Subject: F/10/18

The proposal is for a part 1 and part 1.5 storey standalone building in the grounds of the listed building. It will accommodate 5 small one bedroomed flats; four on the ground floor, and one on the first floor. The version in front of me appears to have been prepared in order to take into account of concerns related to a previously withdrawn application.

Proposed West Elevation

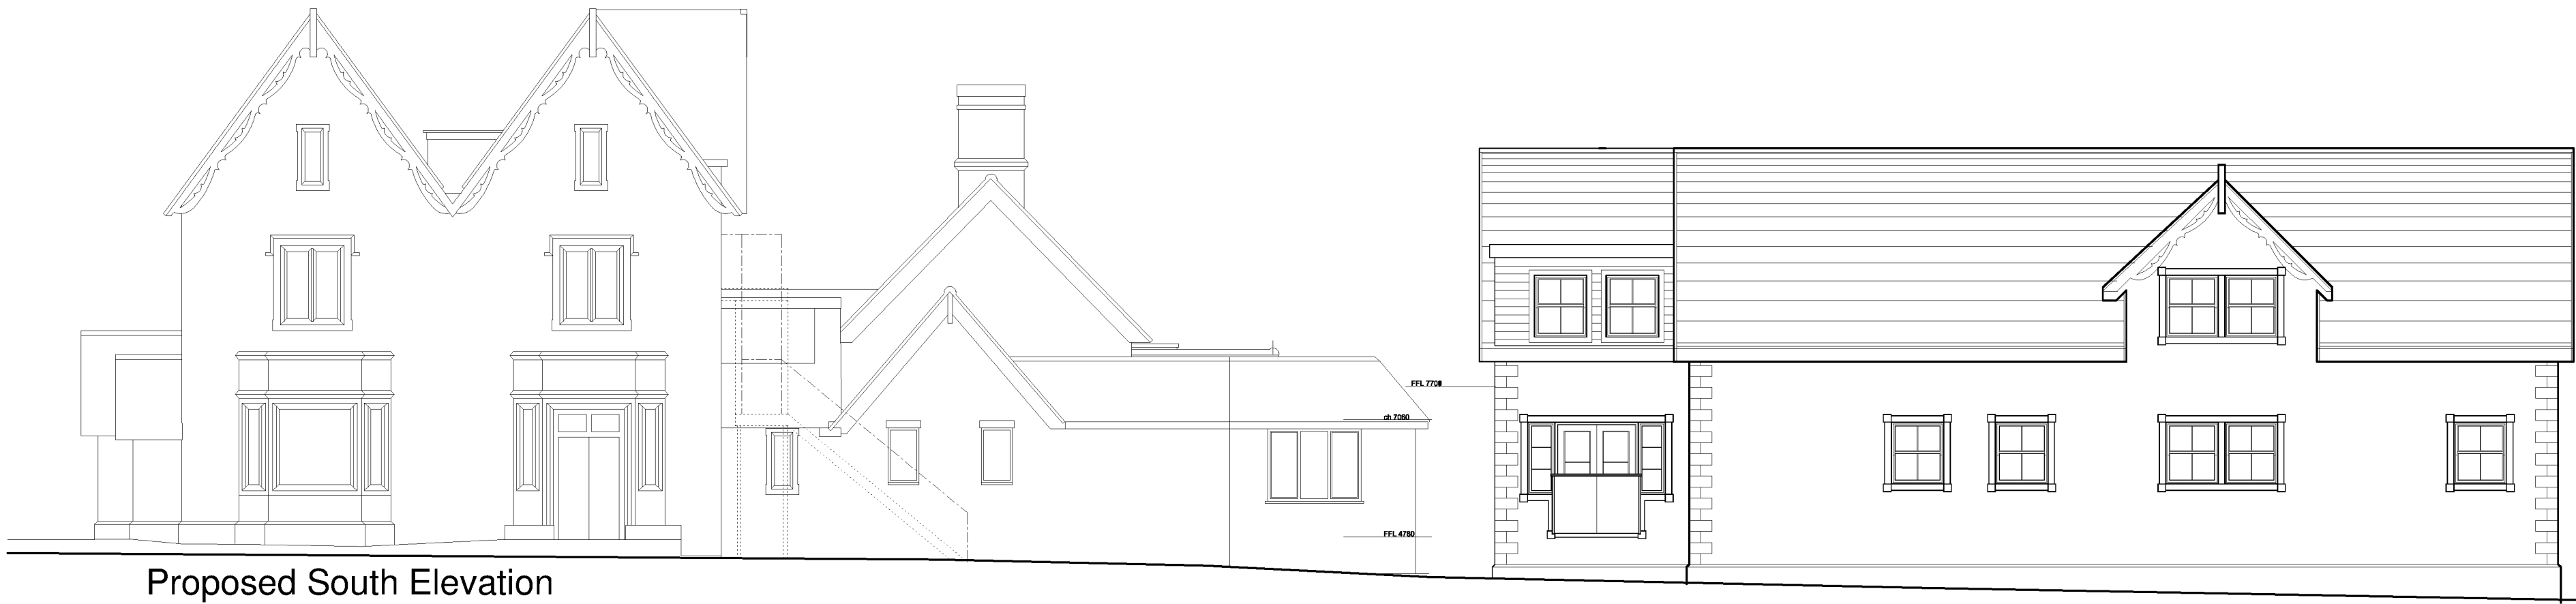
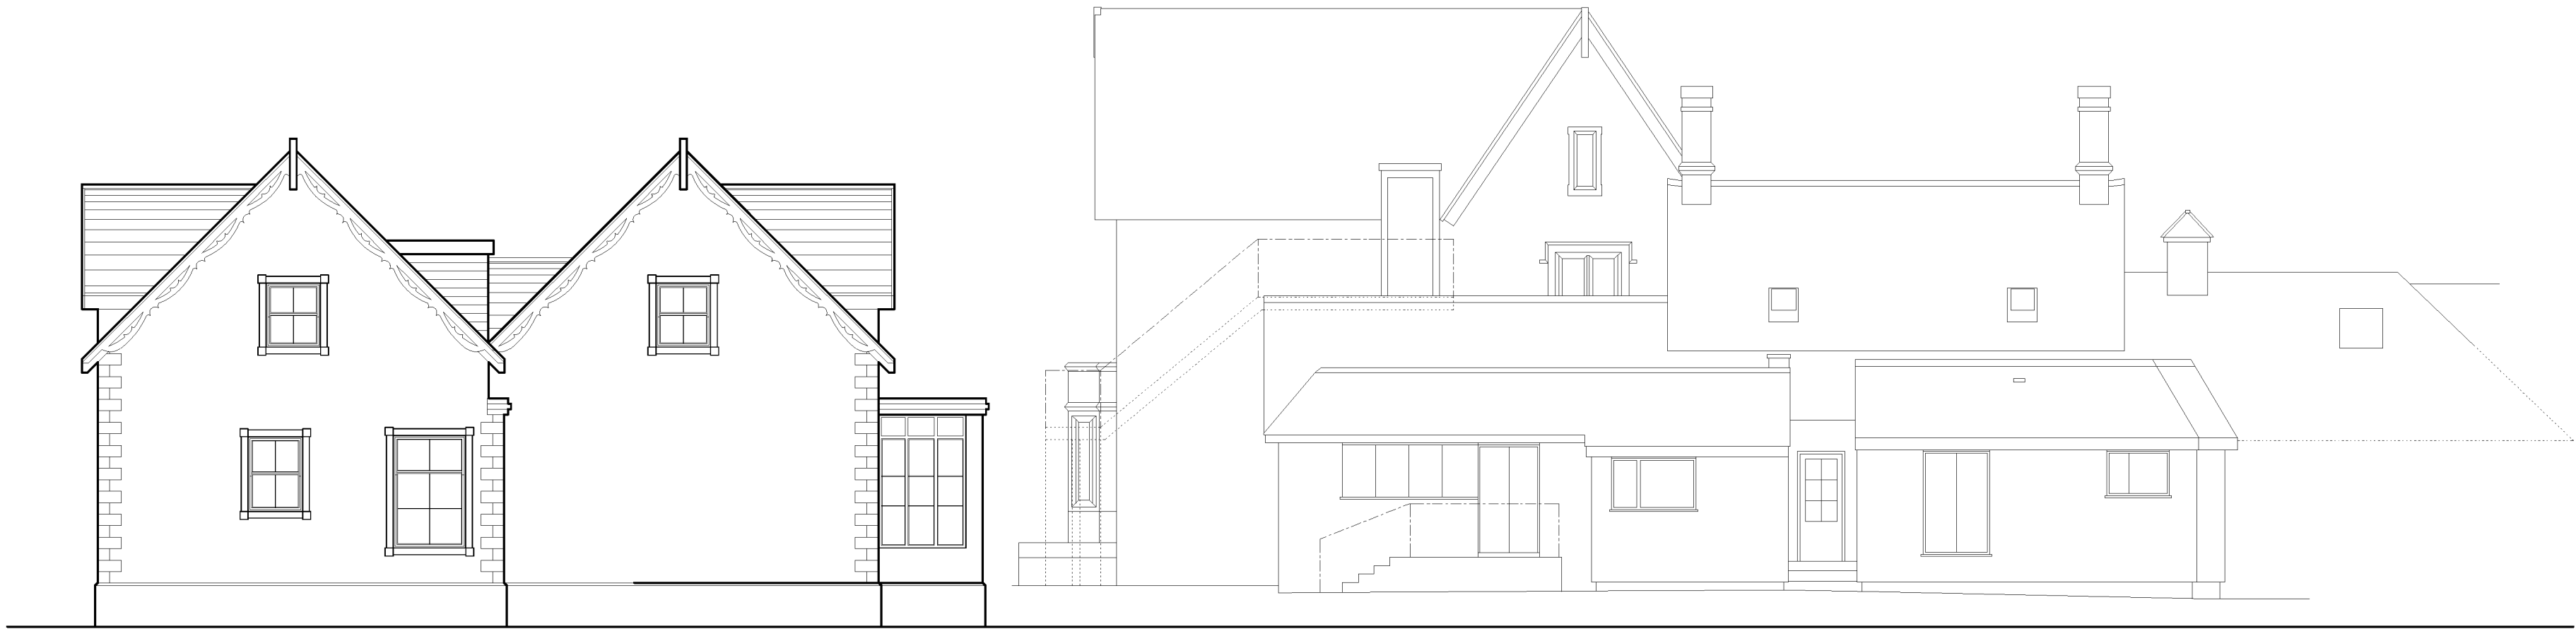
The proposal is predominantly a low level structure, more akin to a previously approved scheme. In addition, the number of dormer windows has been reduced to 3. These dormers are considered to be small in scale and do not appear to dominate the elevation. When viewed from the western elevation, the structure appears to be subservient. However, when viewed from the southern (and northern) elevations it is a substantial structure that appears to dominate the listed building.

The roof structure is very simple in appearance and complements the proposed elevation treatment which appears to closer reflect the host building in terms of materials and treatment. For instance, the western elevation appears to reflect the style of the principal elevation of the listed building. Such an approach is supported, but it should be stressed that the quality of the materials used, along with quality of the build as we details such as the brick bond will greatly influence the success or otherwise of such a scheme.
